**Application** H13-0651-20  
**Location** The War Memorial Seas End Road Moulton Seas End PE12 6LD  
**Proposal** Residential Development - 2 Dwellings

**Name** Ian Marshman, Historic Environment Officer  
**Address** Lincolnshire County Council Lancaster House 36 Orchard Street LN1 1XX

SD19-045/2

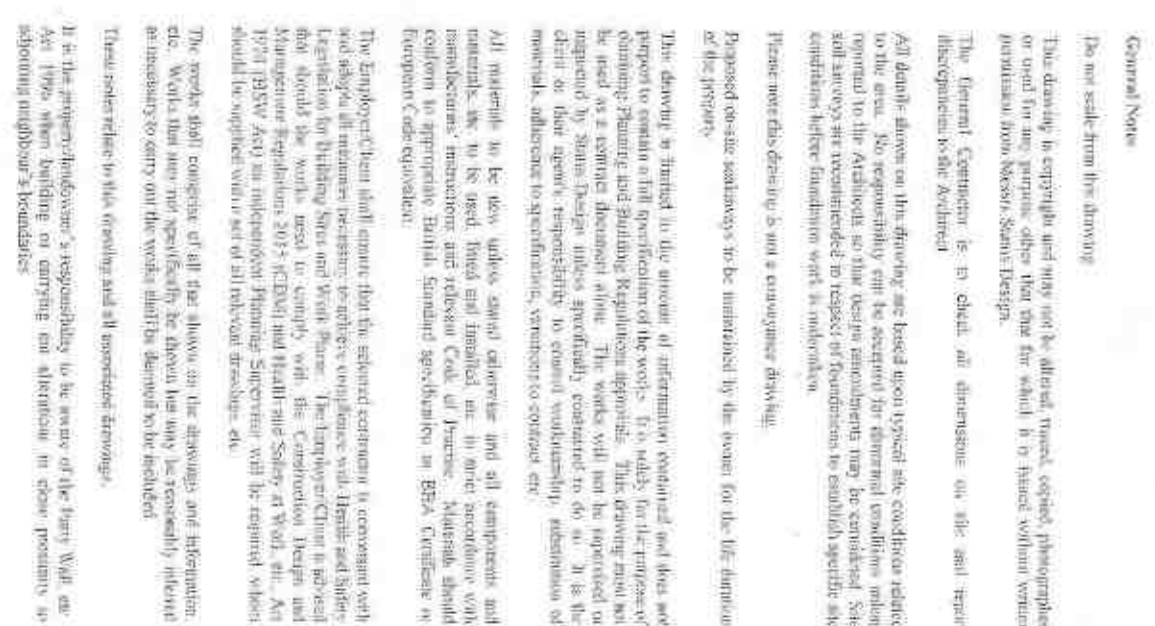
Without careful attention to the design of the proposed access road that comes very close to the memorial itself, and the surrounding proposed garden of remembrance, there is potential for the development to harm the war memorial's setting. Even with the proposed tree screening, which could take many years to become established, the proposed development could potentially give the appearance of the war memorial being set in the front garden of the modern bungalow. This would harm its significance as a monument of communal value, and a focus of public remembrance.

It is recommended that the developer work closely with the Local Planning Authority's Conservation Officer on the design of the access road, garden of remembrance and proposed screening.
